# Response to Submissions Shannon Technology and Energy Park Power Plant (ABP-319566-24)

Response to An Bord Pleanála letter dated 06 September  
2024

Shannon LNG Limited

September 2024

CONTAINMENT PLAN
SCALE: 1:200mm

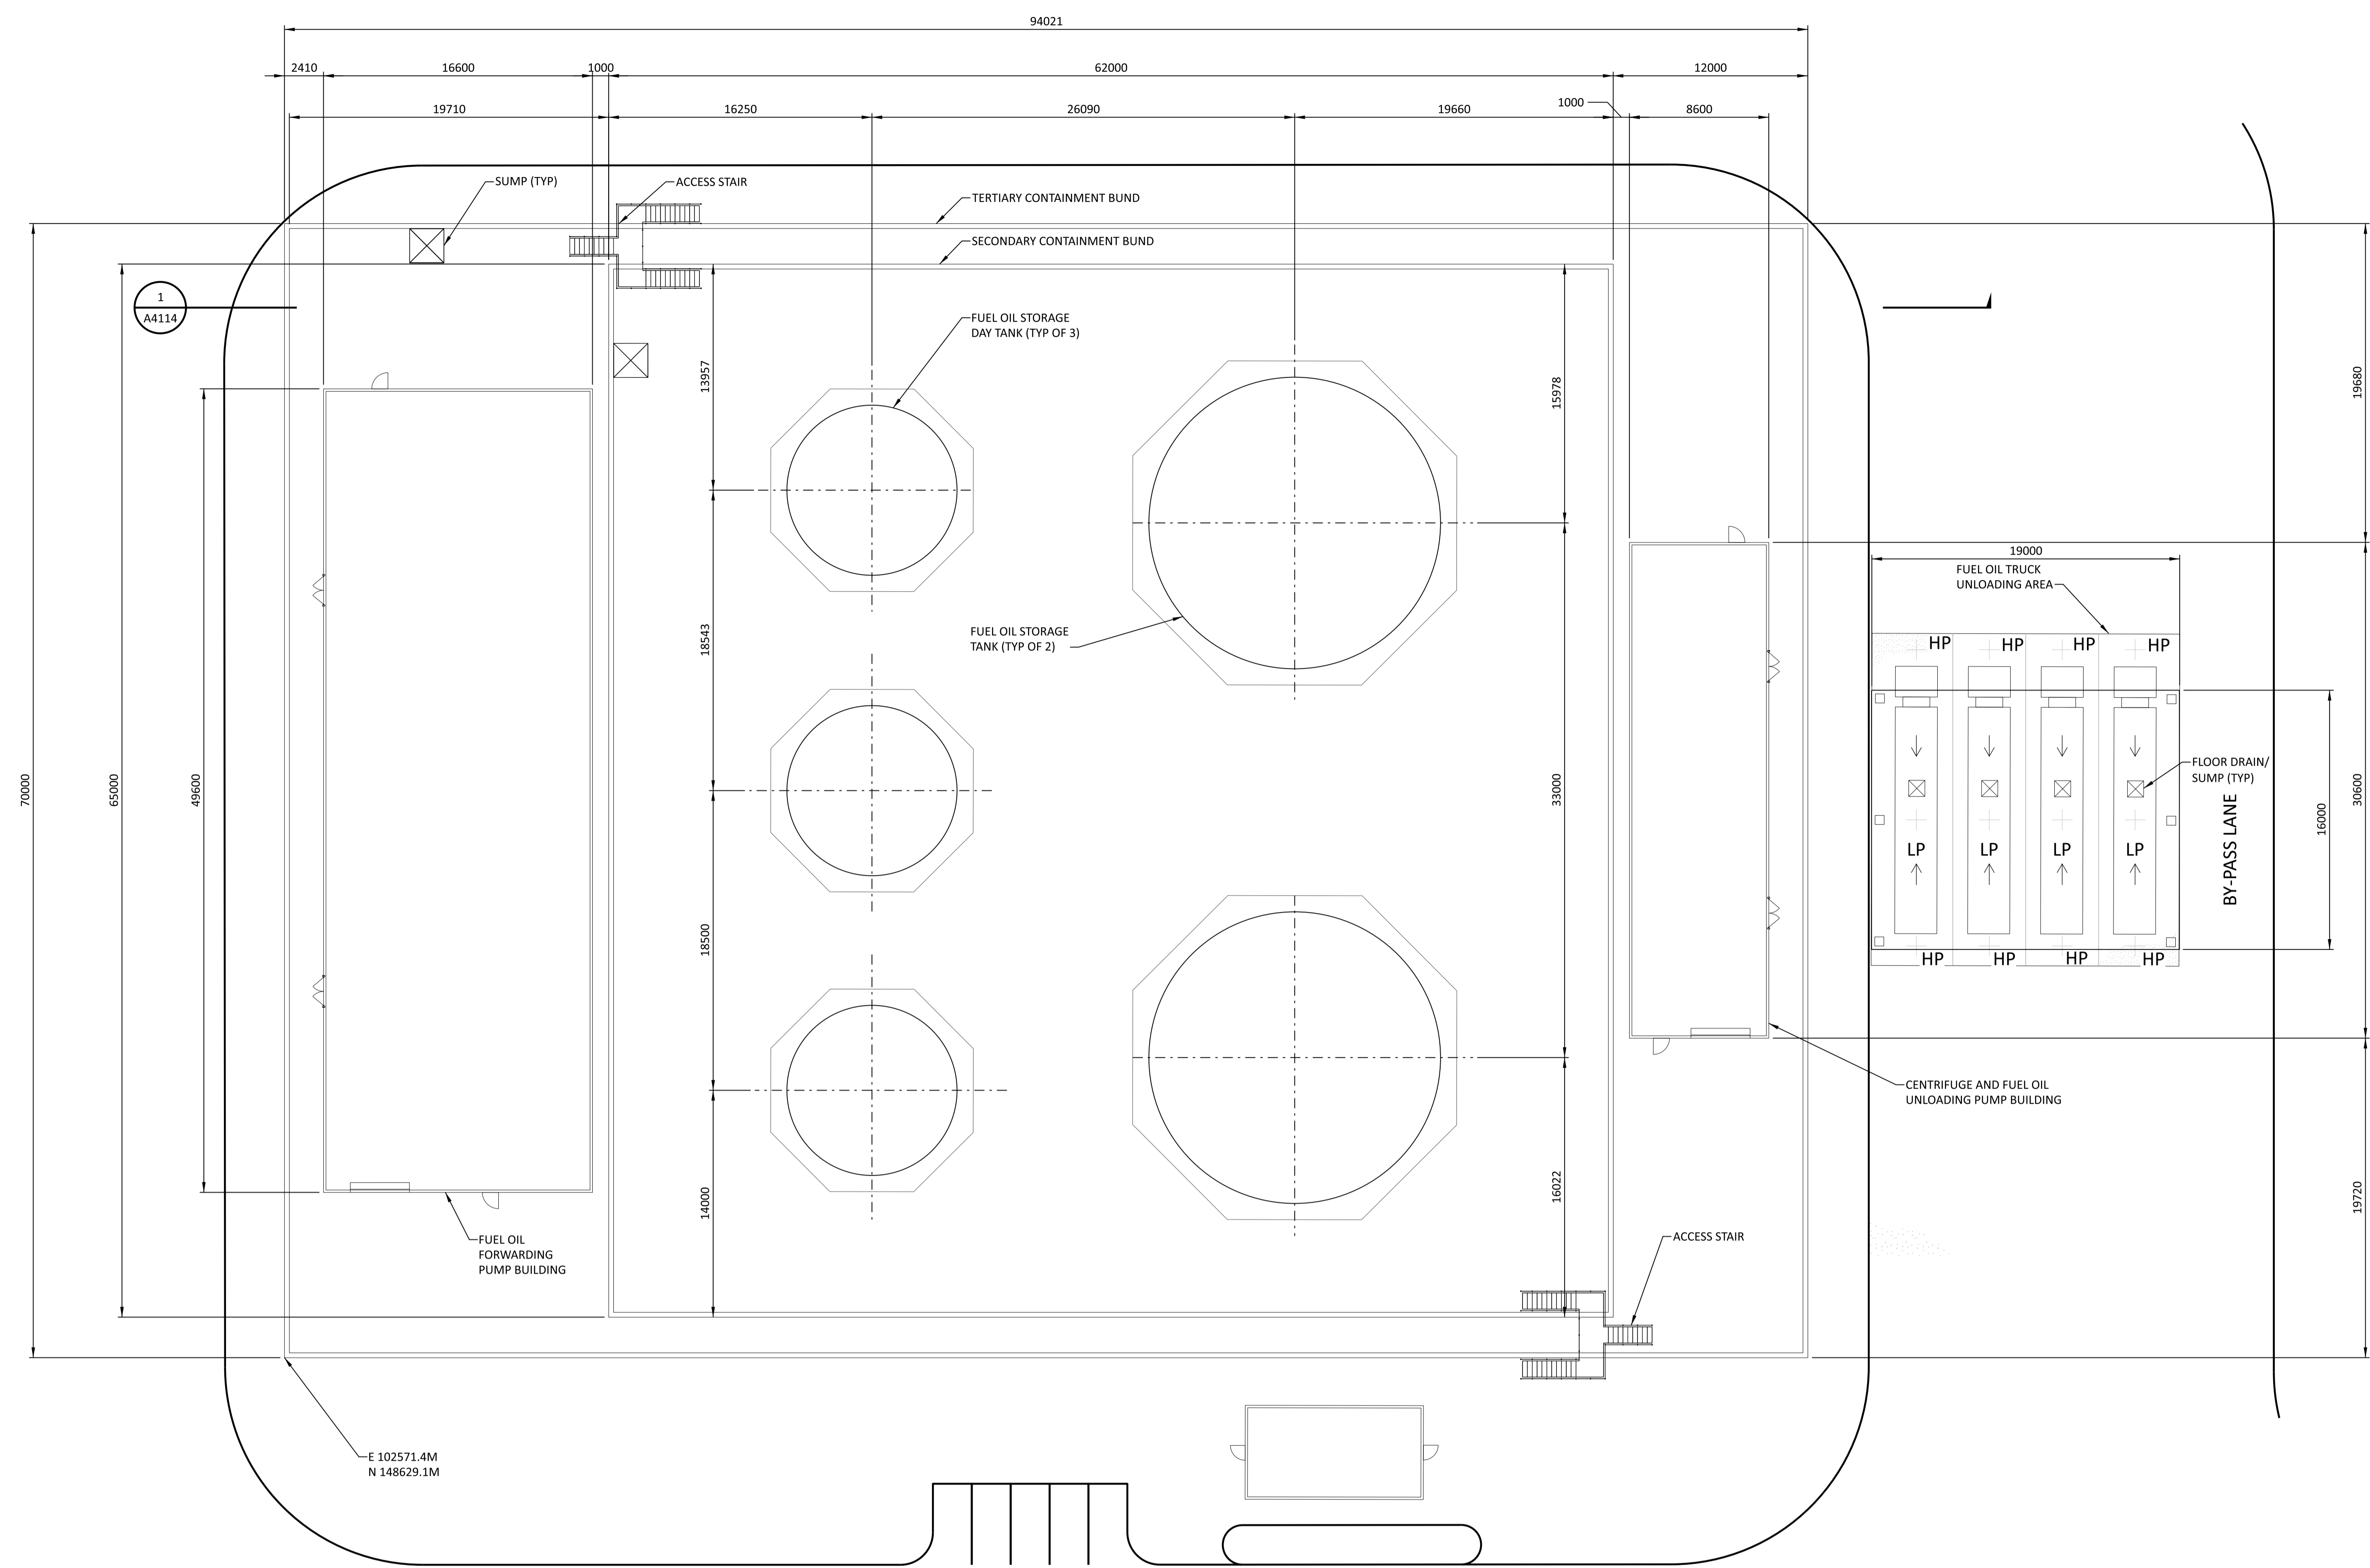
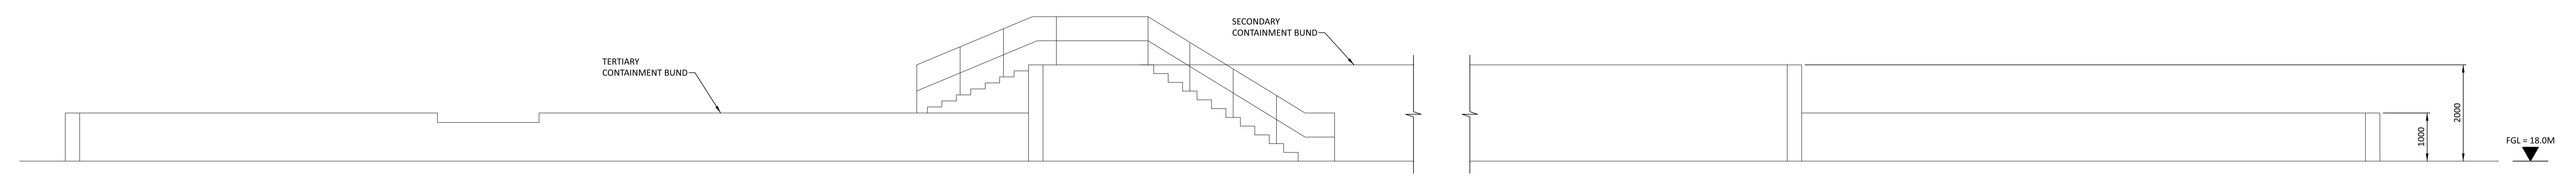
### **3.2.1 Nature of Spillage Containment for the tanker unloading station**

As detailed in Section 2.3.8.2 of Chapter 2 and Section 2.3 of the Appendix 2-5, Tertiary containment, bunding and associated pipework will be designed in accordance with EPA Guidance Note on *Storage and Transfer of Materials for Scheduled Activities (2004)*. The tanks will be located in a bunded area, which will allow for either 110% of the largest tank within the bund or 25% of the total volume of substance within the bund, whichever is the larger, in accordance with CIRIA C736, *Containment systems for the prevention of pollution: Secondary, tertiary and other measures for industrial and commercial premises, (CIRIA, 2014)*.

Refer to planning drawing reference 198291-SS-A4114, which details the design of the containment for the fuel storage and pumping facility including the tanker unloading area.
